Rezoning Petition Review

Rezoning Petition #: 08-144

Location of Property: Approximately 2.60 acres located northwest of the intersection of E. Independence Blvd. and Sardis Road North

RZ1

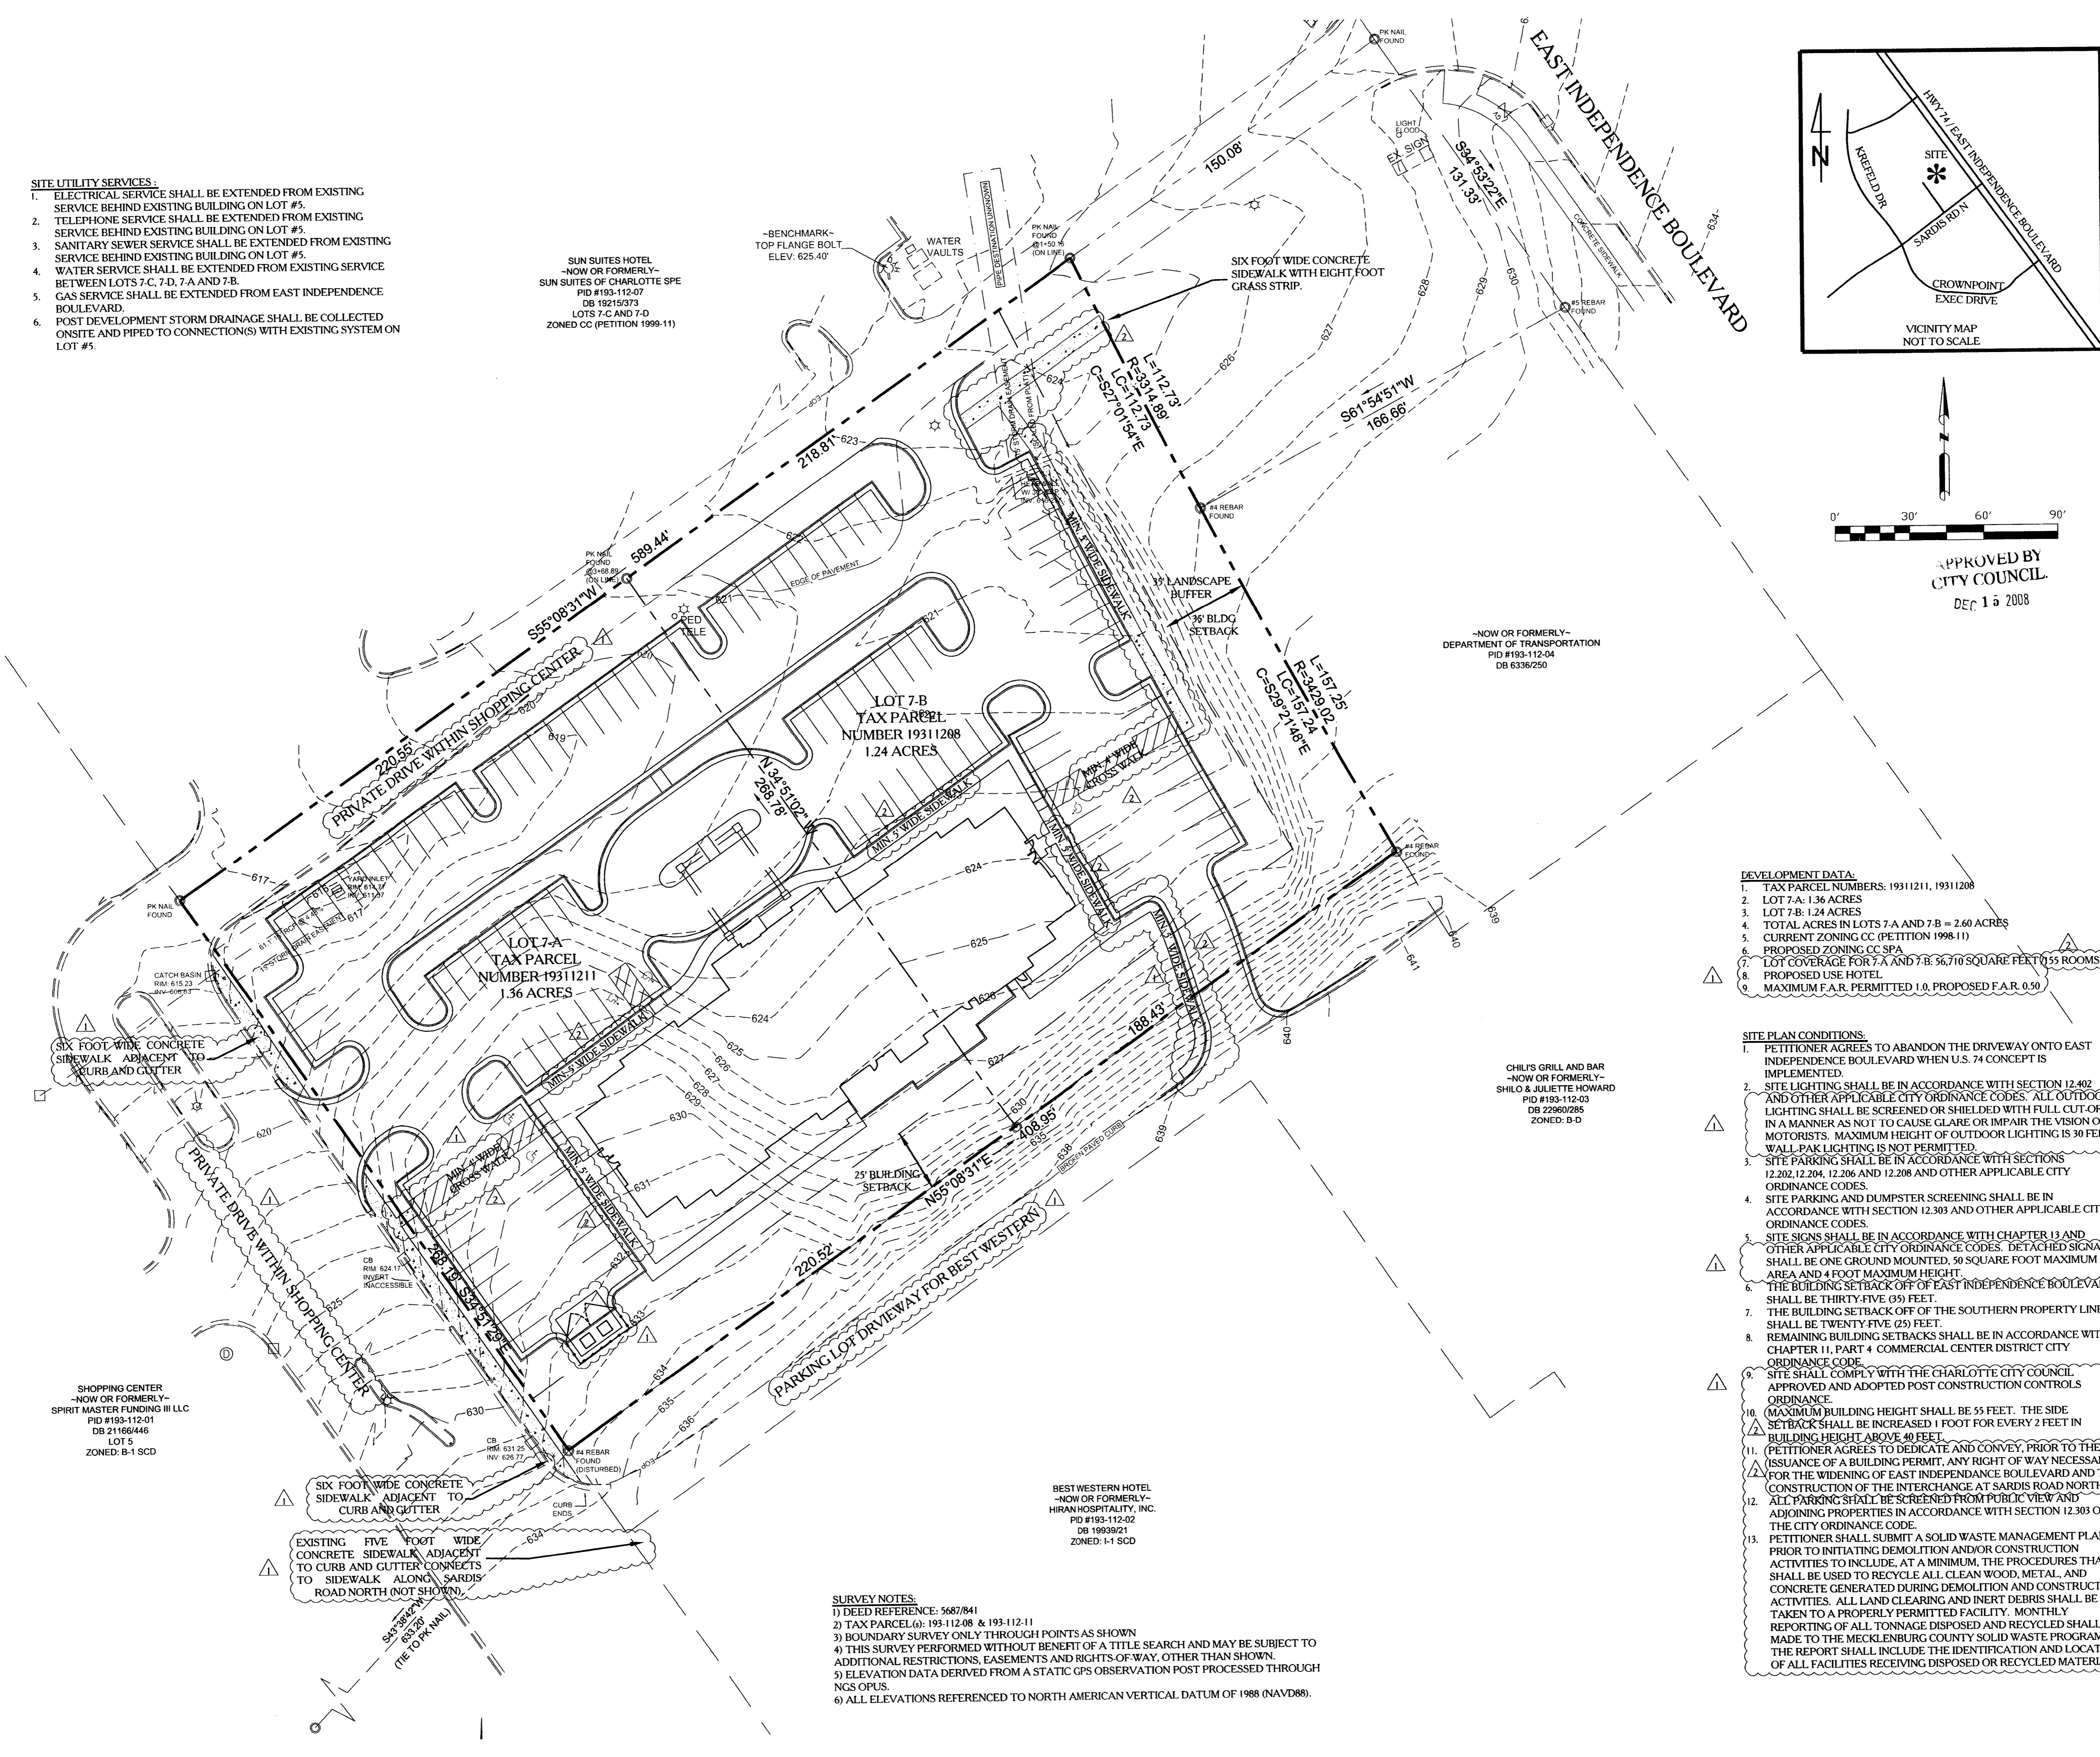
Recommendations Concerning Storm Water: **Please add the following note:**

The petitioner shall comply with the Charlotte City Council approved and adopted Post Construction Controls Ordinance.
